**Re: Residence Inn & Food Hall at 1201 Central Ave NE
Erosion and Sediment Control Plan
Engineer's Stamp Date 2/4/25 (K15E034D) SWQ-2025-00006**

Based on the information in your submittal received on 2/5/25, the ESC Plan can't be approved until the following comments are addressed. **Additional comments in red are for the resubmittal received on 2/7/25.**

Principal Engineer, Planning Dept.
Development and Review Services

210046 PROJECT NUMBER C102 SHEET NUMBER

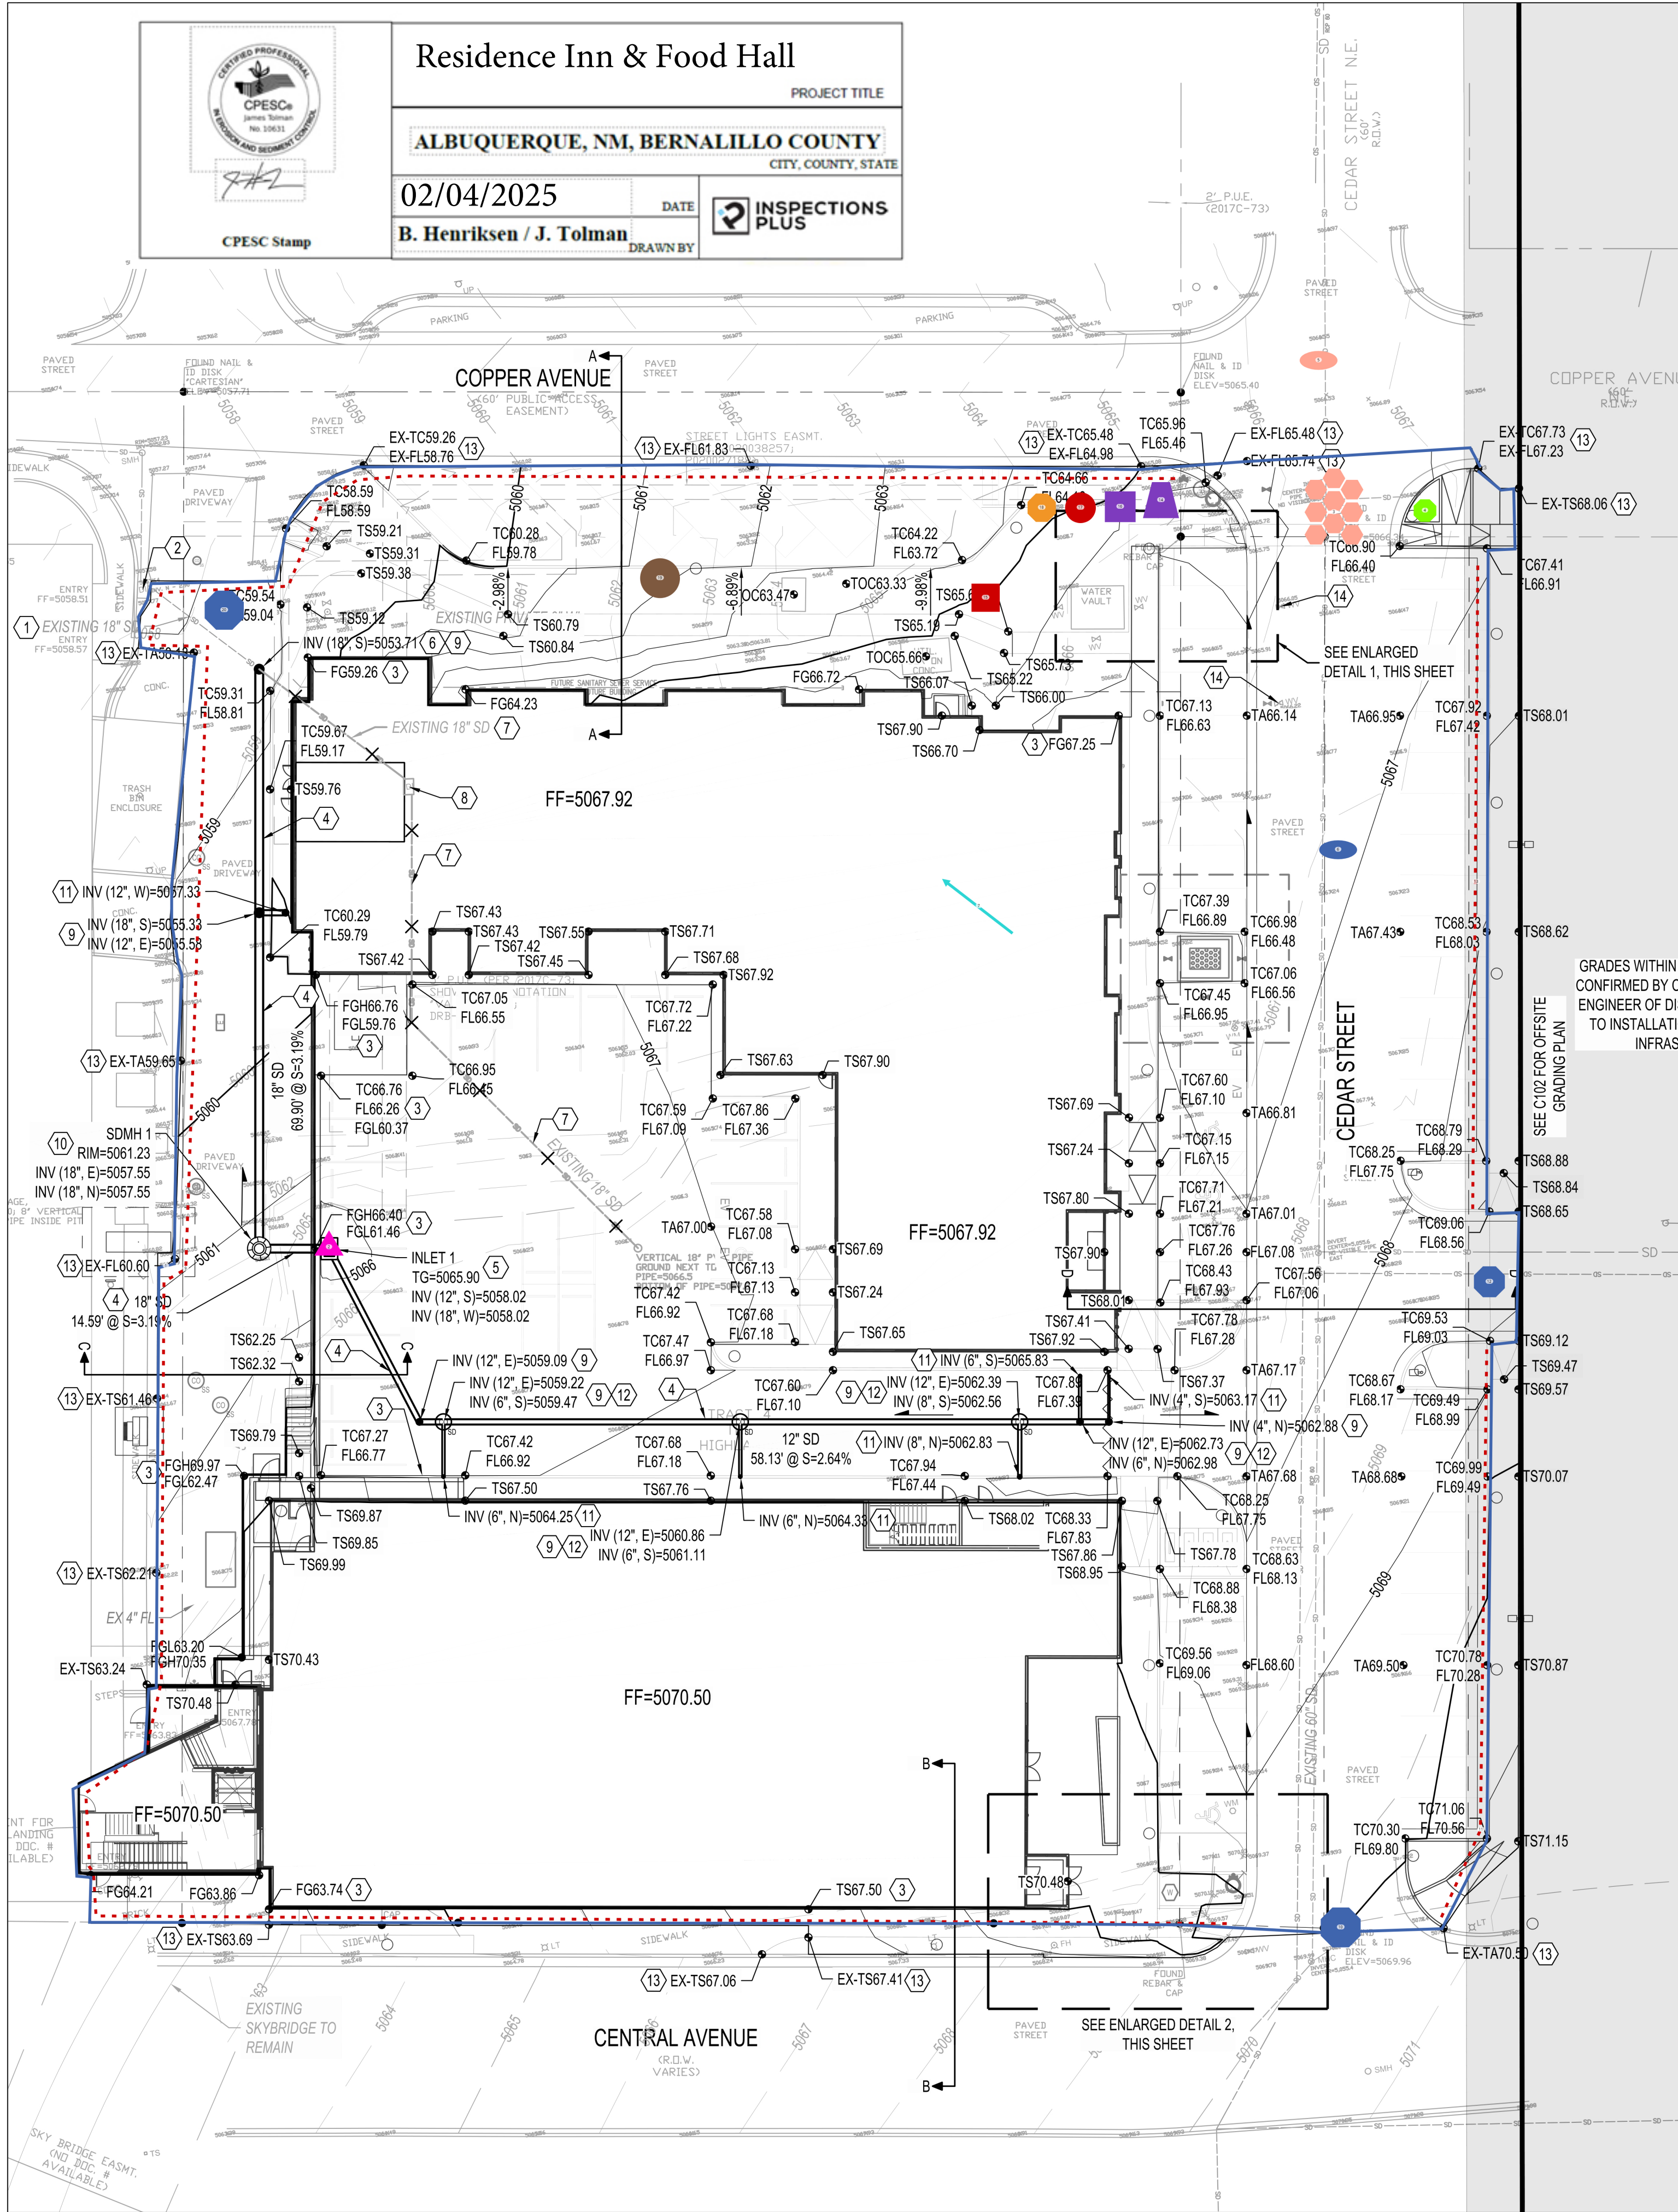
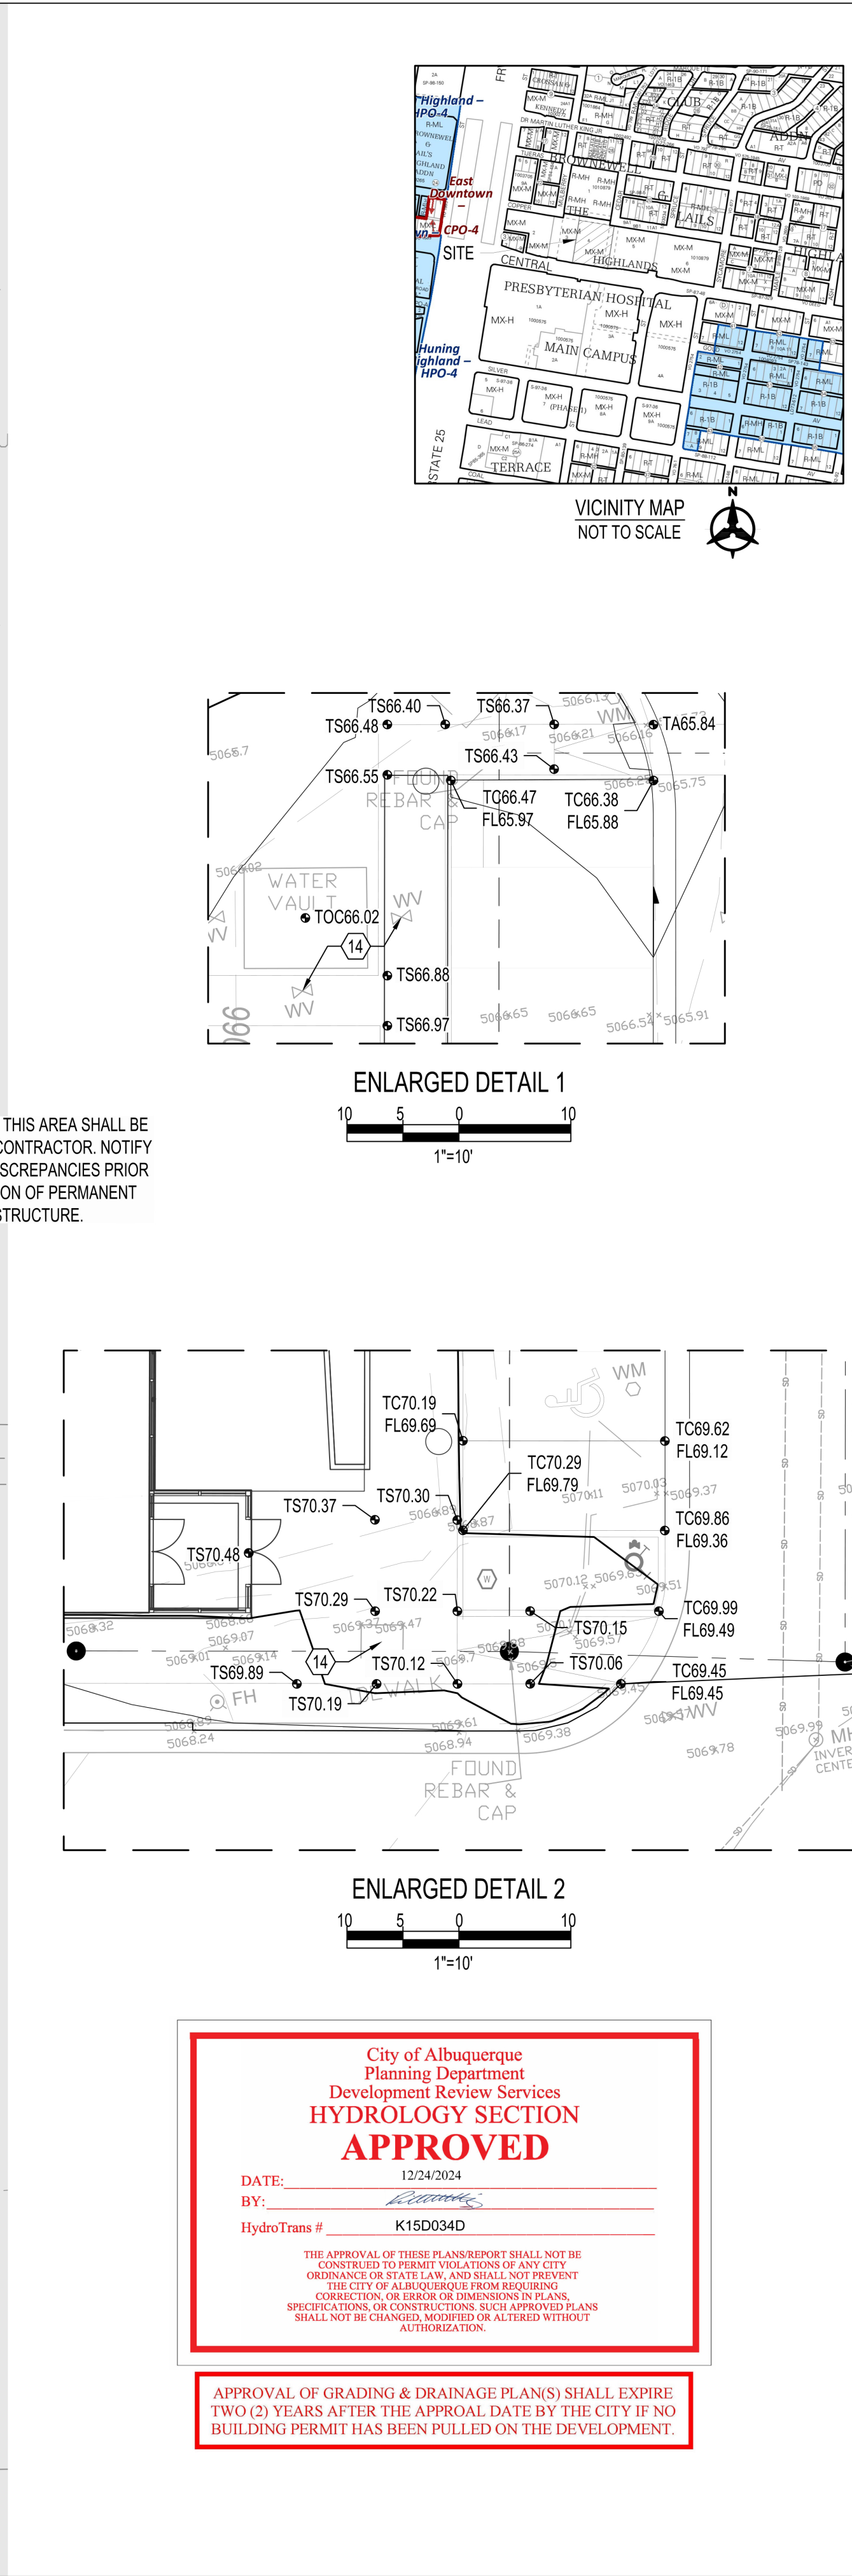
2. Identify locations of concentrated flow paths that enter and exit the disturbed areas. **Identify the concentrated flow path along the west flowline of Cedar St. and specify temporary rock stabilization there.** Identify locations where sheet flow enters and exits the disturbed area. Show on-site drainage patterns of stormwater before and after major grading activities as required by CGP 7.2.4.f.

3. Temporary sediment traps are required upstream of the two concentrated flow Discharge Points. **Ponds are still missing. Alternatively, specify a 6" aggregate base course to temporarily stabilize the finished grade in the parking areas for the duration of the building construction. The rock can be added to the paving specification to increase durability or decrease asphalt thickness.**

4. The construction exits must be moved out of the path of the concentrated discharges. **Add a note to "Keep Construction Exits away from Discharge Points.**

6. The limits of disturbance and property boundary are not in the same location, so a single line can't be used to represent them both. The sidewalks and C&G in Cedar St. are being removed. The contours indicate new grades on all of the existing paving in Cedar St., indicating disturbance to the whole area, so there aren't any limits of disturbance along Cedar St. The Cedar St Right of Way has been vacated, so there aren't any boundary lines there either. Cedar Investors, LLC owns Spruce St., so there isn't a property boundary at that limit of disturbance.
7. Update the engineer's stamp date on all sheets each time a change is made to any of the ESC plan sheets. The sheets were changed, but the stamp date wasn't updated.
8. All submittals for this ESC Plan must be made in the entity number SWQ-2025-00006. Use only one number per SWPPP.
